**WEST SUSSEX COUNTY COUNCIL
STRATEGIC PLANNING CONSULTATION**

SUBJECT: R/194/12/A - 1 x internally illuminated fascia sign, 1 x internally illuminated projecting sign, 1 X internally illuminated ATM collar, 1 x non-illuminated metal window marketing unit and various vinyls applied to inside face of glazing.

Halifax Plc, 2, Ash Lane, Rustington, West Sussex, BN16 3DT

Proposed Elevations

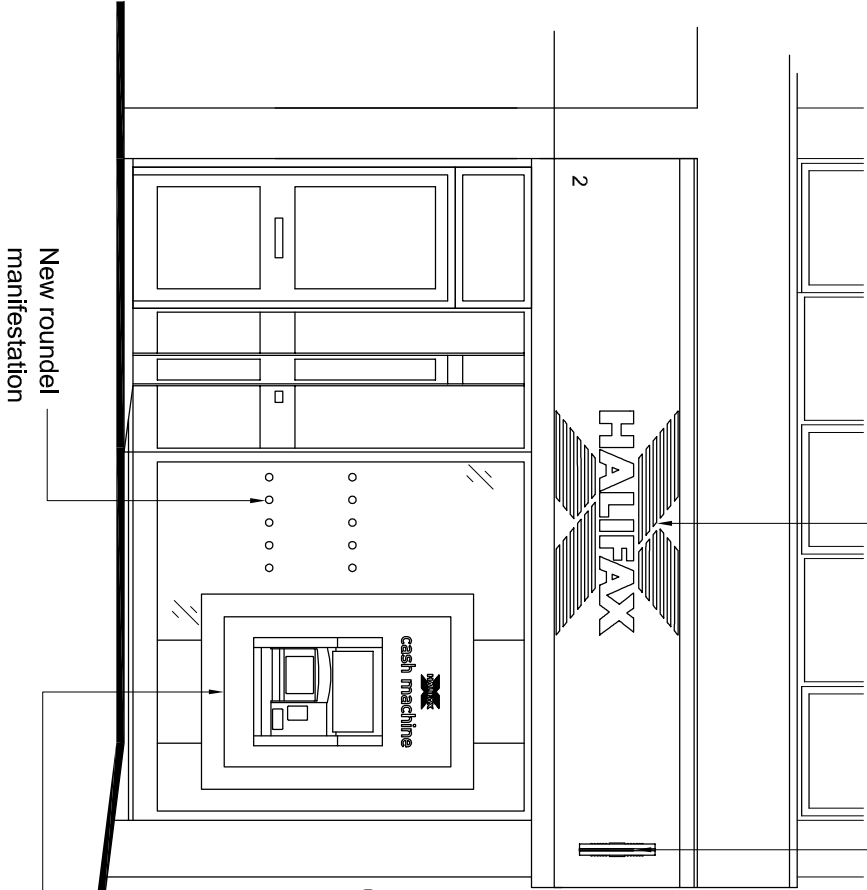
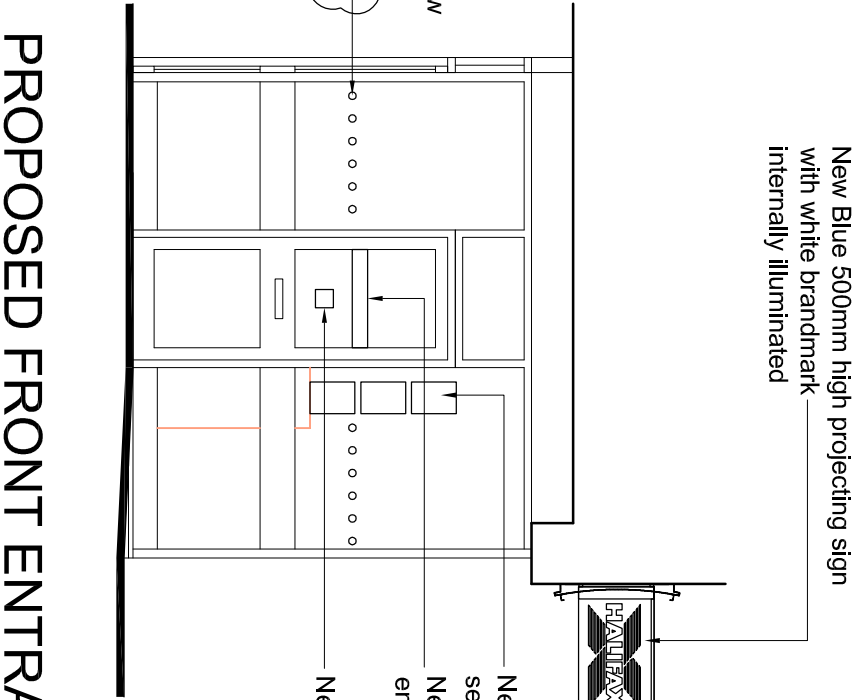
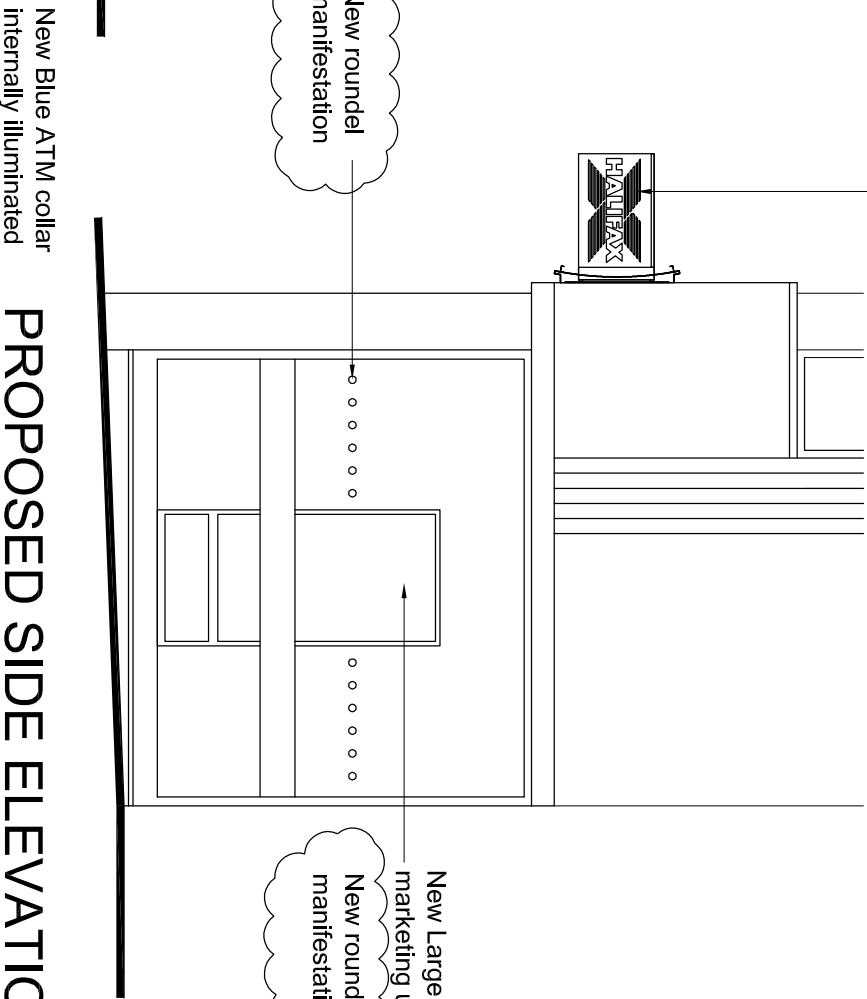
Upon inspection of the plans, it does not appear that these signs are in a location where they could obstruct the highway.

Provisionally, there would be no highway objection to these signs, providing they do not exceed 800cd/m².
